**KIRKLEES METROPOLITAN COUNCIL
INVESTMENT & REGENERATION SERVICE**

**DELEGATED DECISION TO DETERMINE APPLICATIONS FOR
CONSENT, AGREEMENT OR APPROVAL REQUIRED BY CONDITION**

Reference No: 2018/44/92802/W

Site Address: Former Midlothian Garage, New Mill Road, Holmfirth,
HD9 7LN

704-EVF-01

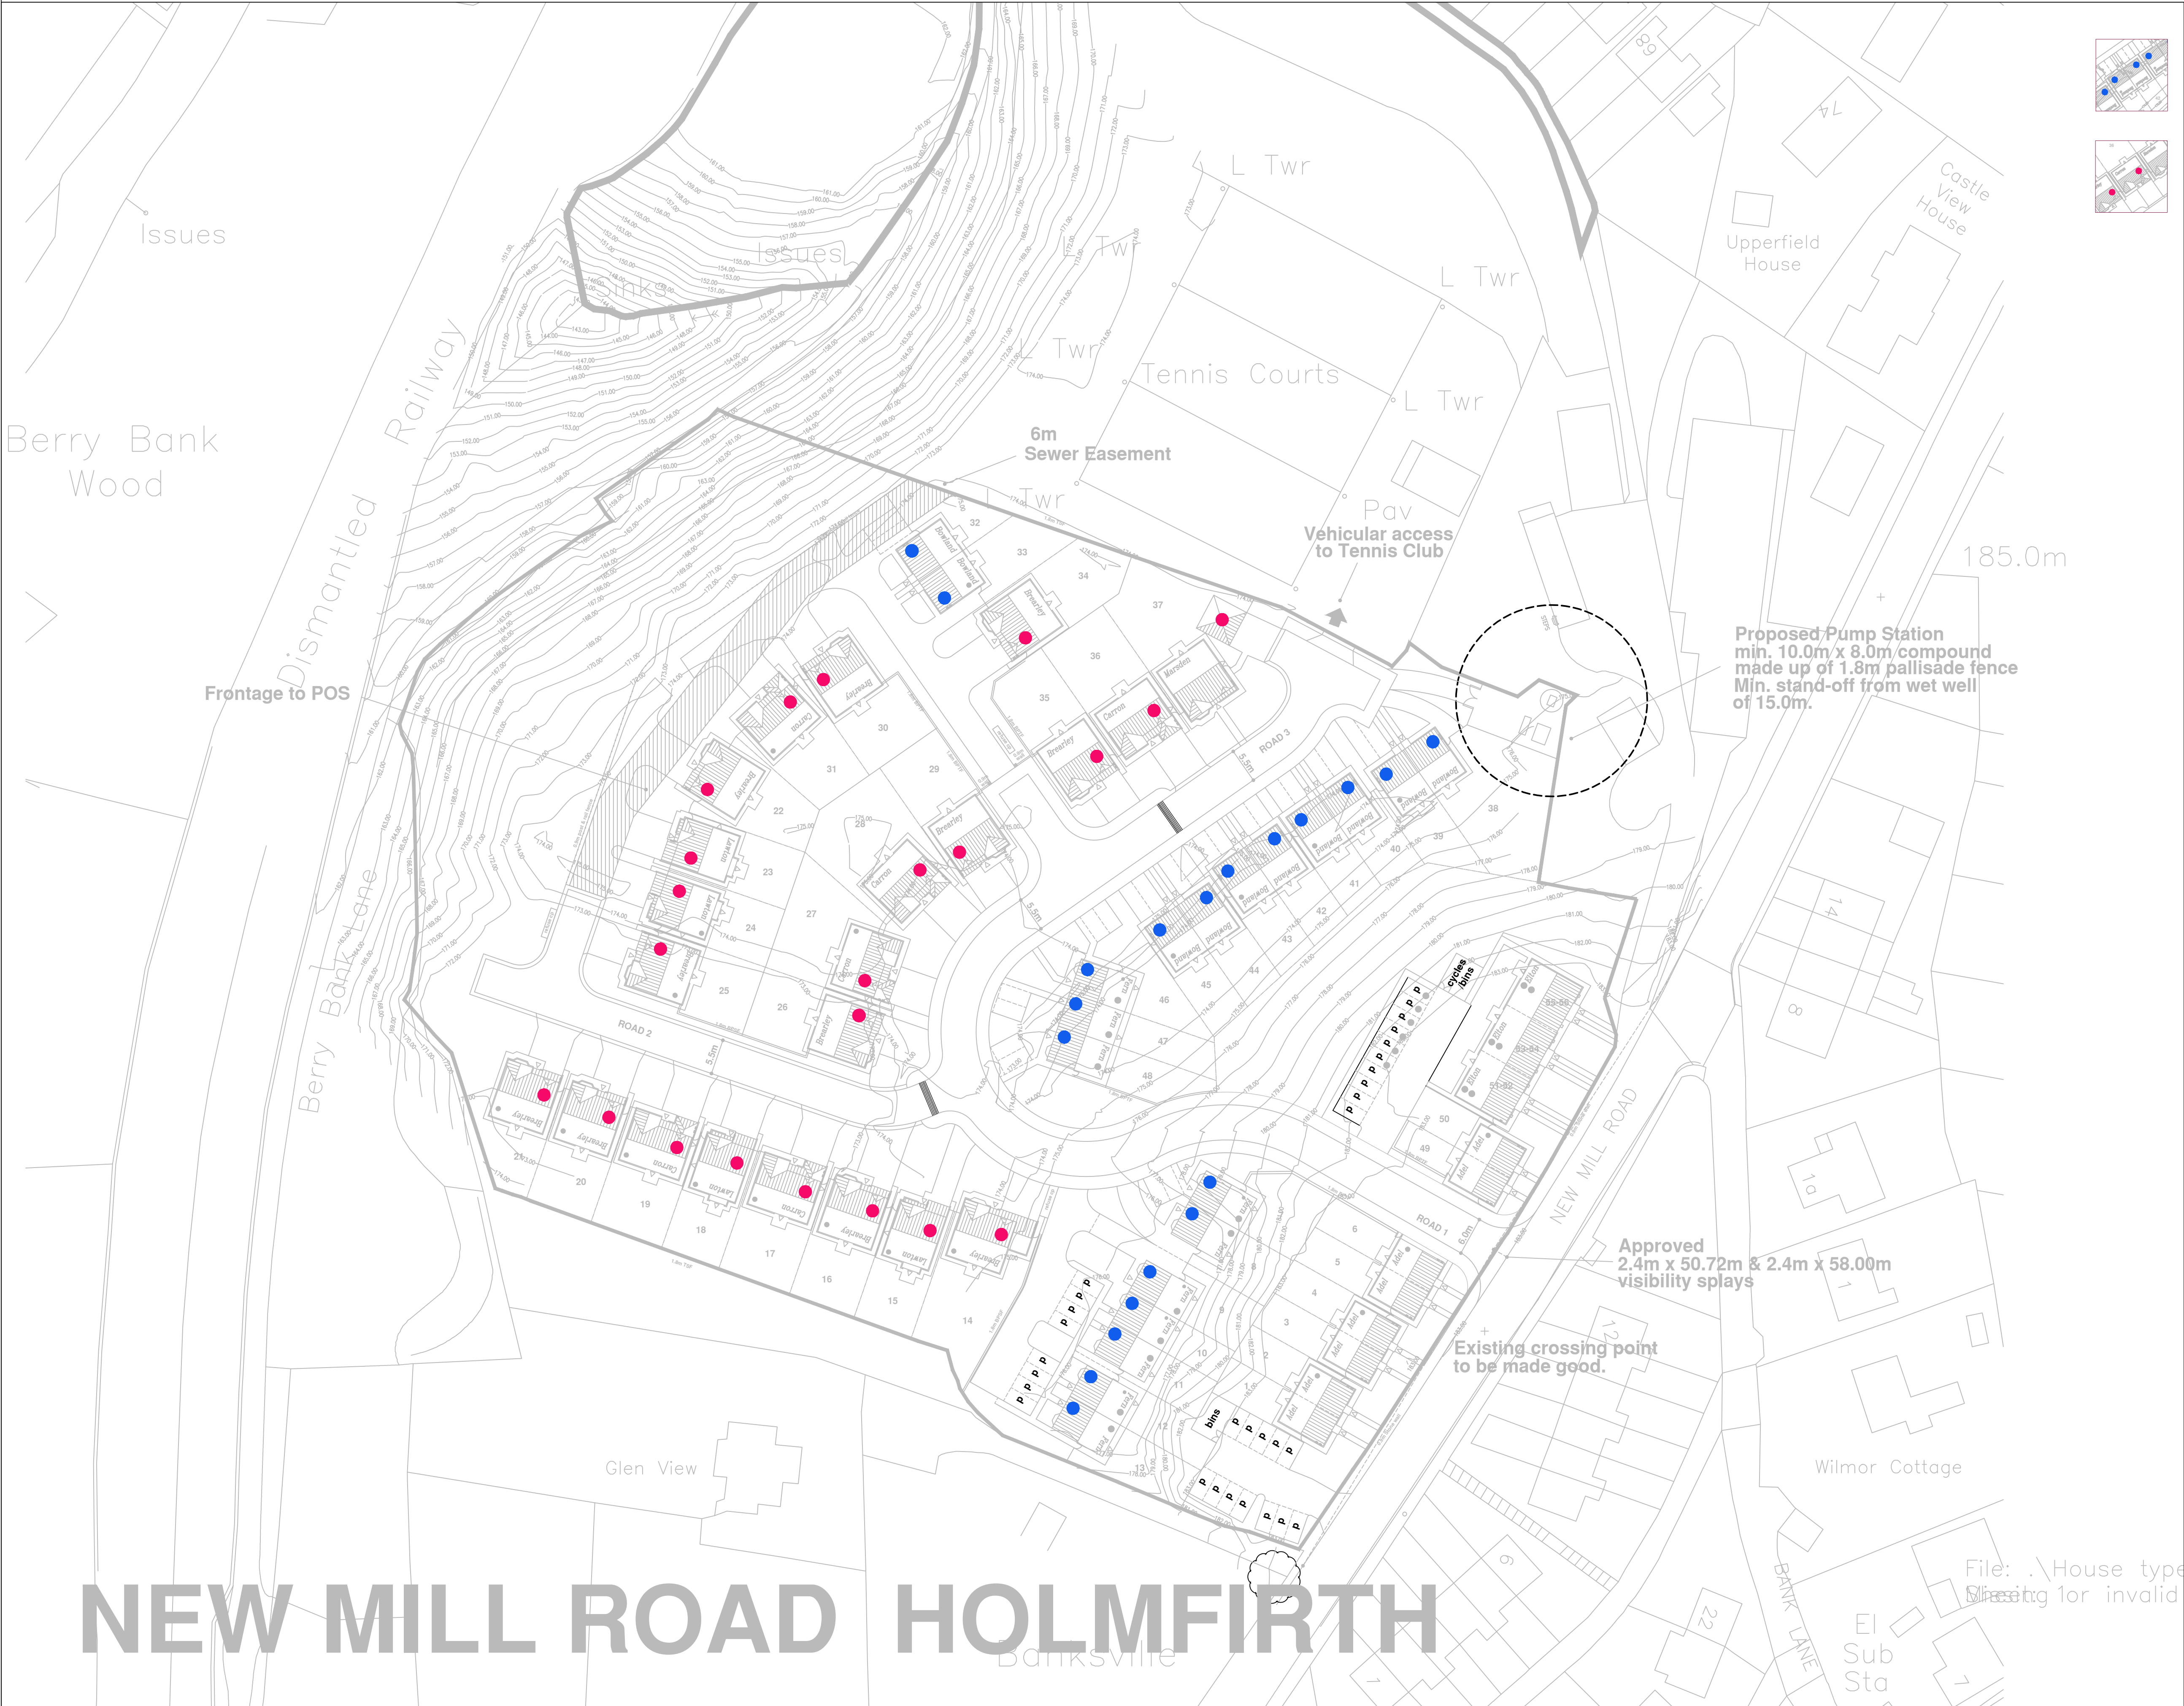
The council’s Environmental Health officer (EHO) noted that the submitted details showed EV charging facilities only to selected plots with a 13A external socket. This was not satisfactory as charging facilities are required to every plot with a dedicated parking space and one point for every ten unallocated spaces. Furthermore, 13A sockets are insufficient as sockets need to meet the minimum requirements specified in “Electric Vehicle Homecharge Scheme minimum technical specification by the Office for Low Emission Vehicles”. A mode 3 charger with a type 2 socket providing a constant current of 16A would be satisfactory.

An acceptable standard would be a charging point for every plot that provides at least Mode 3 charging with a Type 2 socket outlet capable of providing a continuous supply of 16A and a maximum supply of 32A.

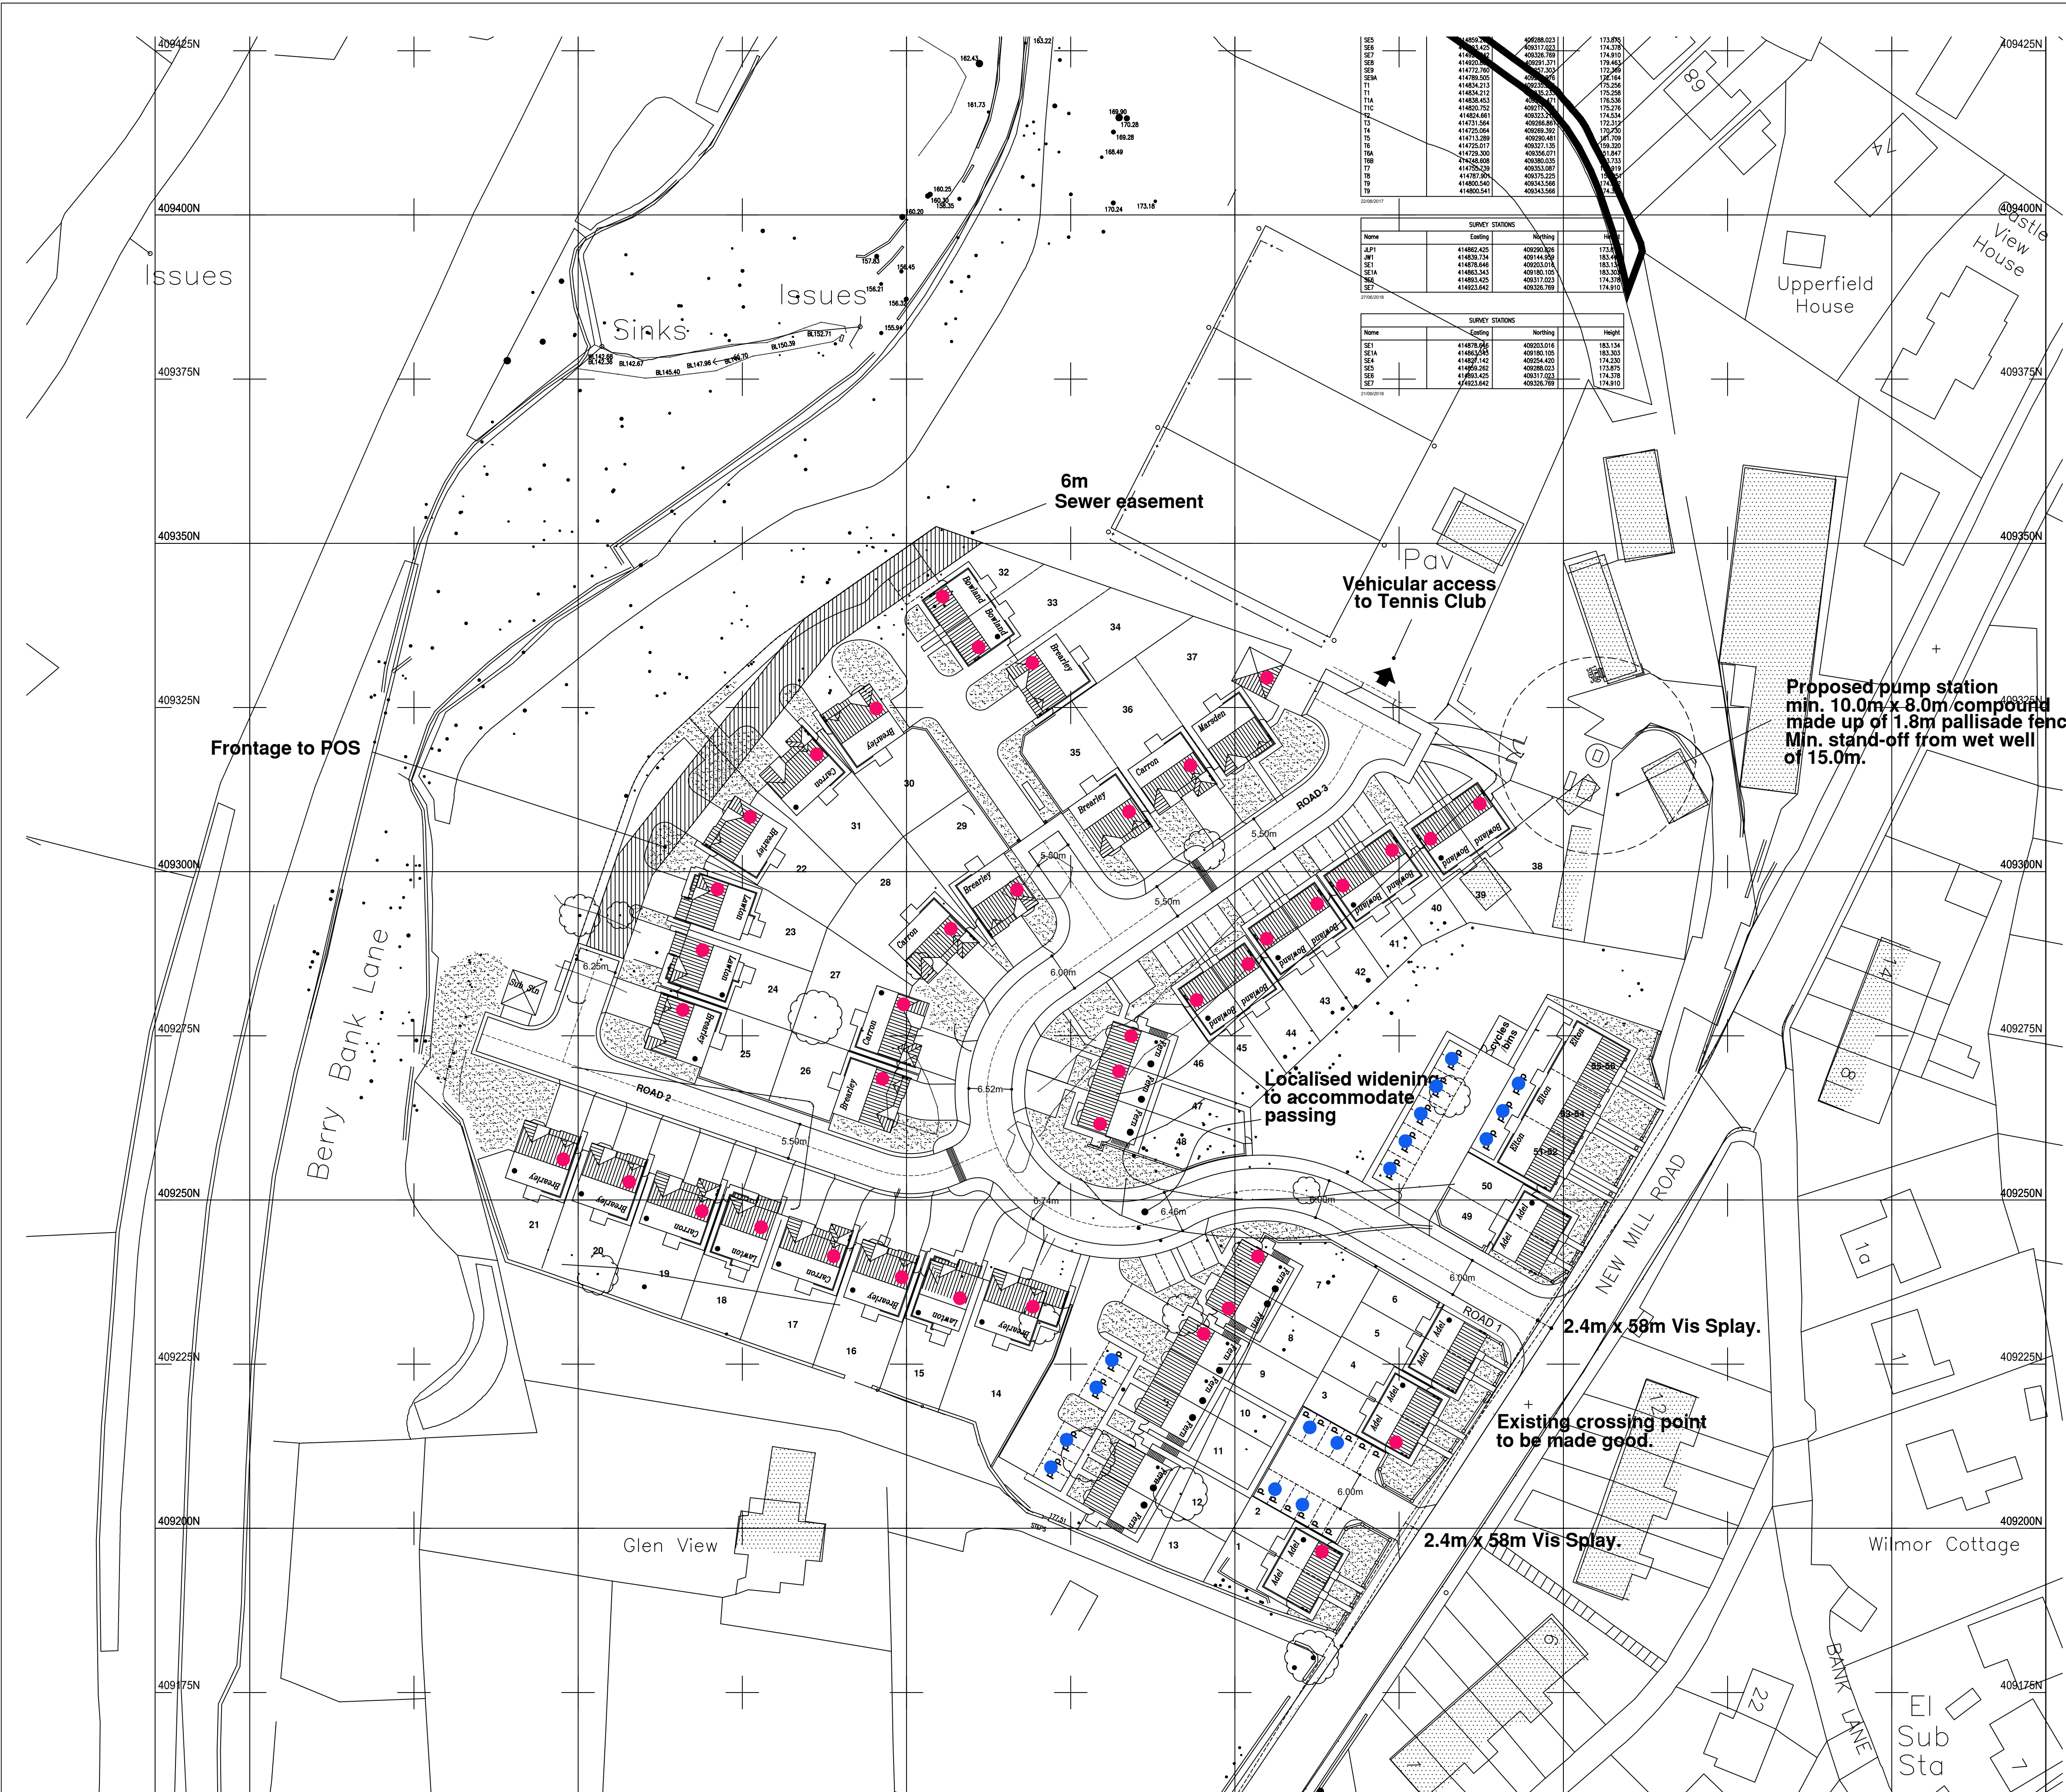
The EHO noted the provision of charging points to every property supplied by a 16A fused spur for the occupier to fit their own plug if necessary. All plots with parking within the curtilage and those with detached parking would have a Mode 3 charger. However, the details showed a mode 2 charger with a 13A socket. The EHO considers that mode 2 chargers to a 13A socket are unacceptable as the charge would not be delivered over a reasonable timescale. The proposals were therefore considered unacceptable.

The submitted information advises that an electric vehicle charging point will be provided to every property and that these will be supplied by a 16A fused spur. All of the plots with parking within the curtilage will have a Mode 3 charger and plots with detached parking will have a Mode 3 charger. The charger information provided shows the Mode 2 charger which has a 13A socket outlet.

The provision of a charger to each property meets the scale of provision that is required by this Authority. However, Mode 2 chargers are not considered to be acceptable, particularly when they have only a 13A socket outlet. This is insufficient to fully charge a typical electric vehicle within a reasonable time scale. Also, details of the socket outlet for the proposed Mode 3 chargers are not provided.
